December 7, 2023

RESPONSE TO REVIEWER COMMENTS

RE: HONG/KAO RESIDENCE REMODEL ADDITION AND NEW DADU
PERMIT 2306-124

ROOF PLAN
1/4" = 1'-0"

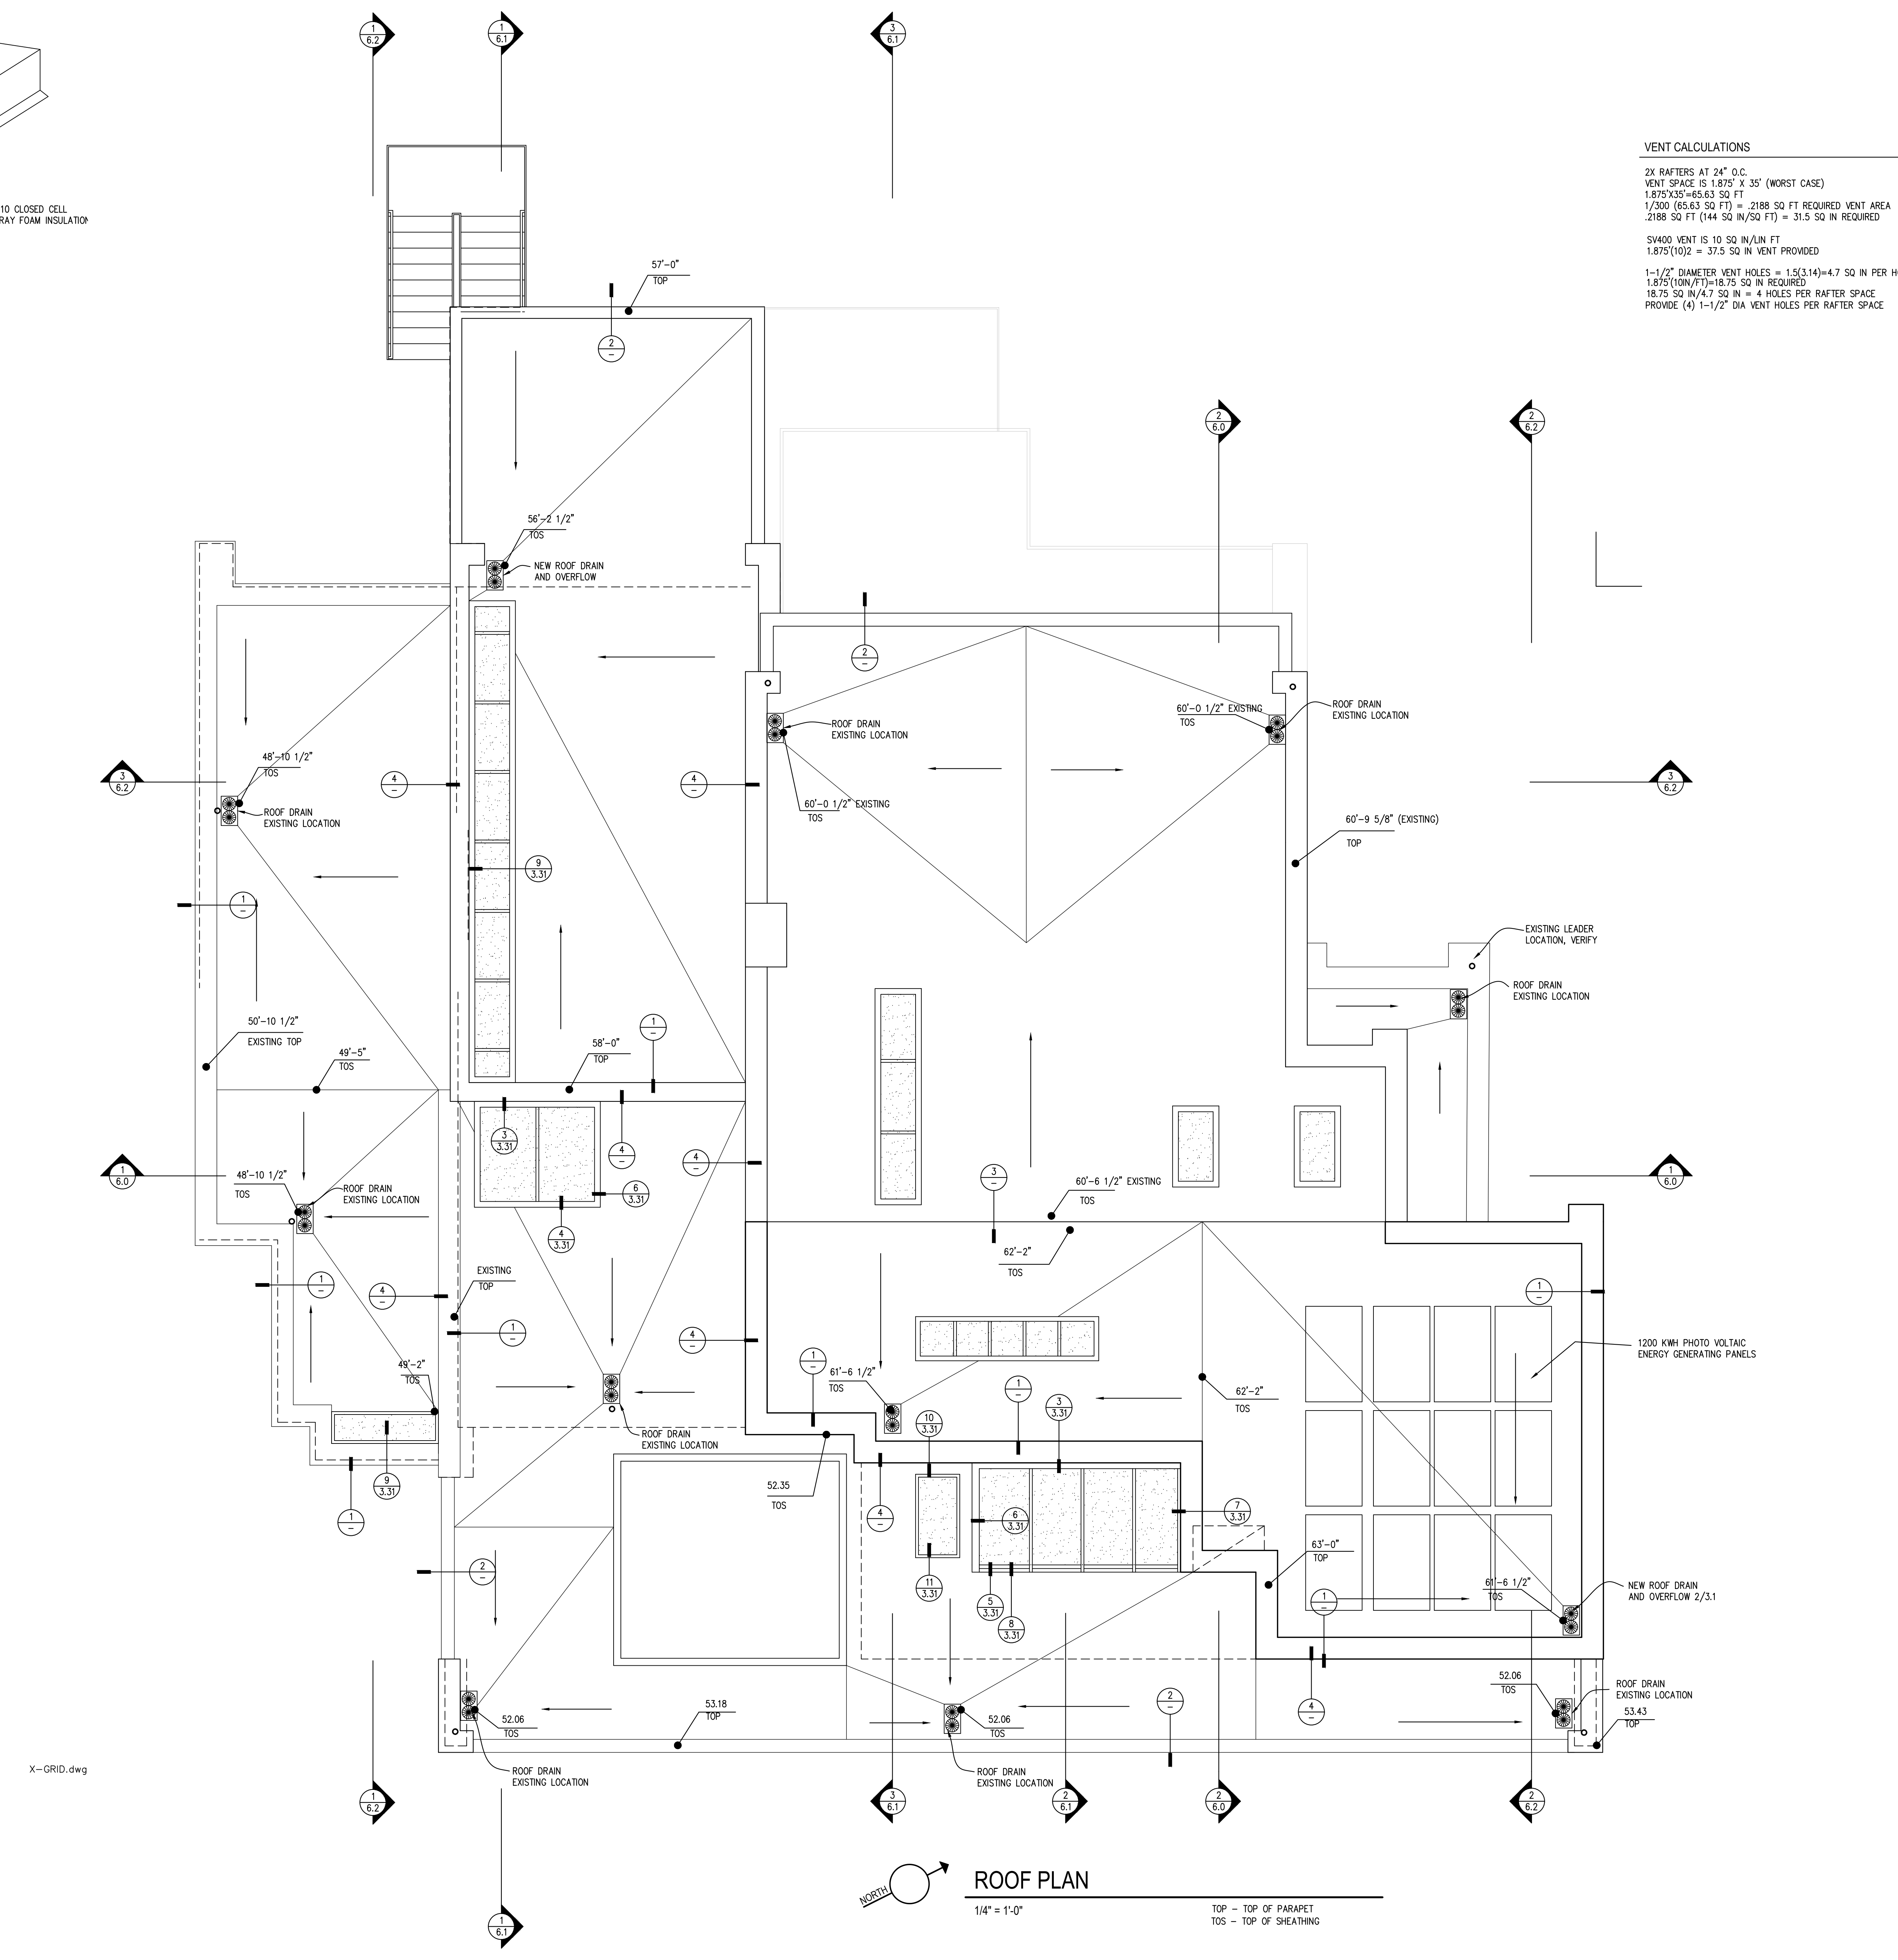
5. The PV array has been increased in size to provide 4200 kwh for a total of 3 points in that category
6. Air leakage has been changed to 2.1, 3.0 air changes per hour.
7. We are increasing the PV system size, a pvwatts calculation is attached.
8.
 - a. The number of panels is shown on 3.3
 - b. The panel weight is shown on 3.3
 - c. The equipment listing requirement is noted on 3.3
 - d.
 - e. Required pathways are shown, not sure this is applicable to a flat roof.

WINDOW TYPES

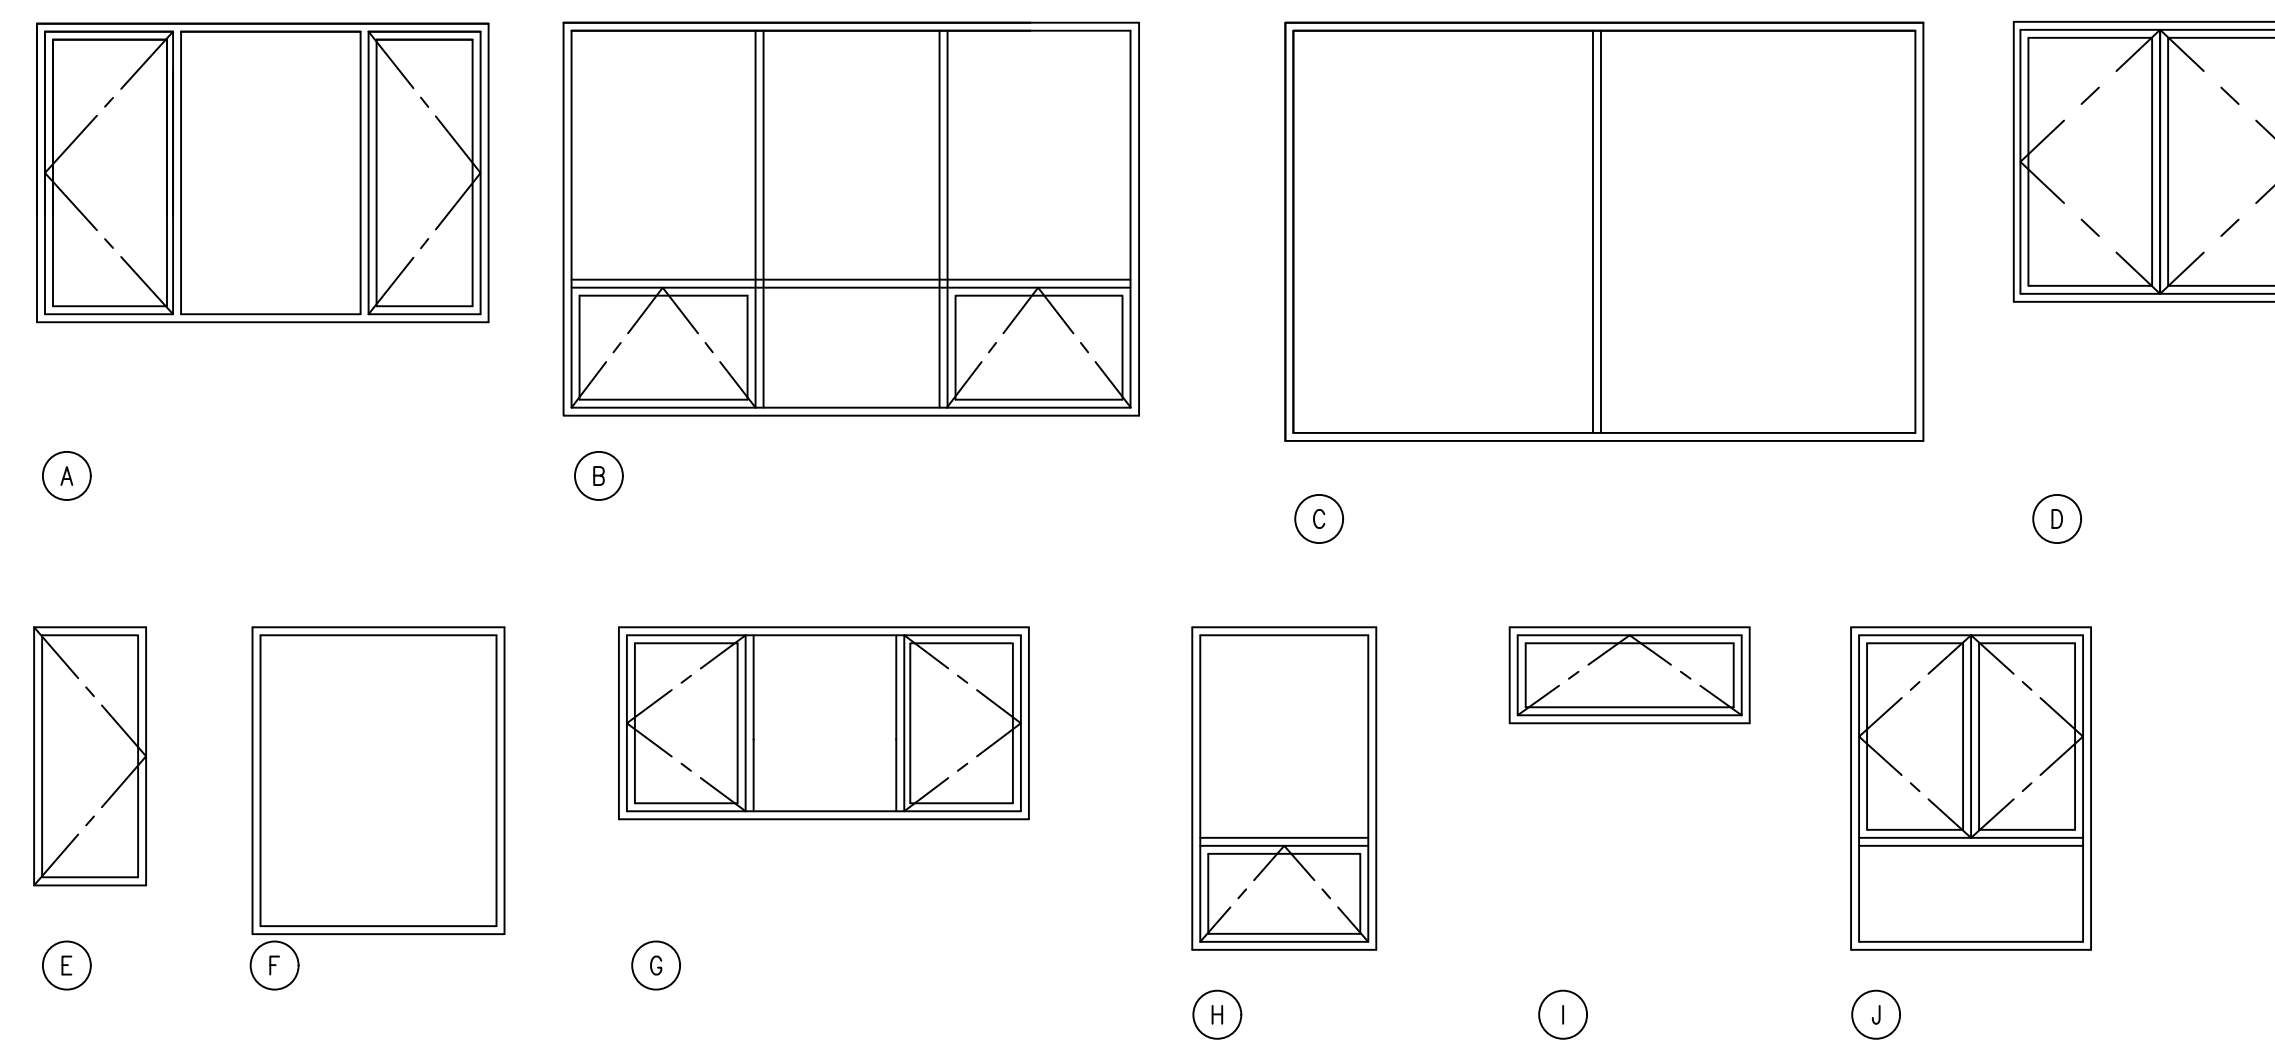
3. It is noted on D3.0. I added the note to 5/d3.1.
4.
 - a. Safety glass is noted on the schedule
 - b. Dimensions added to window types on schedule
 - c. Windows 7 & 11 are noted as safety glass

- d. note added to schedule regarding ASTM F2090
 - e. The roof surface exterior to window 14 is two feet below the sill, less than 72". Window 15 is less than one foot above the roof below.

- f. Window types for 20 and 21 were backwards and revised now
 - g. see f.
5. Door 5 is existing, as is door 6 and they are not planned to be replaced.

6.
 - a. ASTM F2090 is noted on the schedule
 - b. Fall protection noted at windows 2, 6 & 8
 - c. Window 8 revised for egress. If this space was directly connected to the lower floor garage access we wouldn't need the egress window. (See 1)

- d. See window types
 - e. Safety glass added.
 - f. Safety glass added.
 - g. Safety glass added.
7. Safety glass noted. No door supplier will make a door without safety glass.
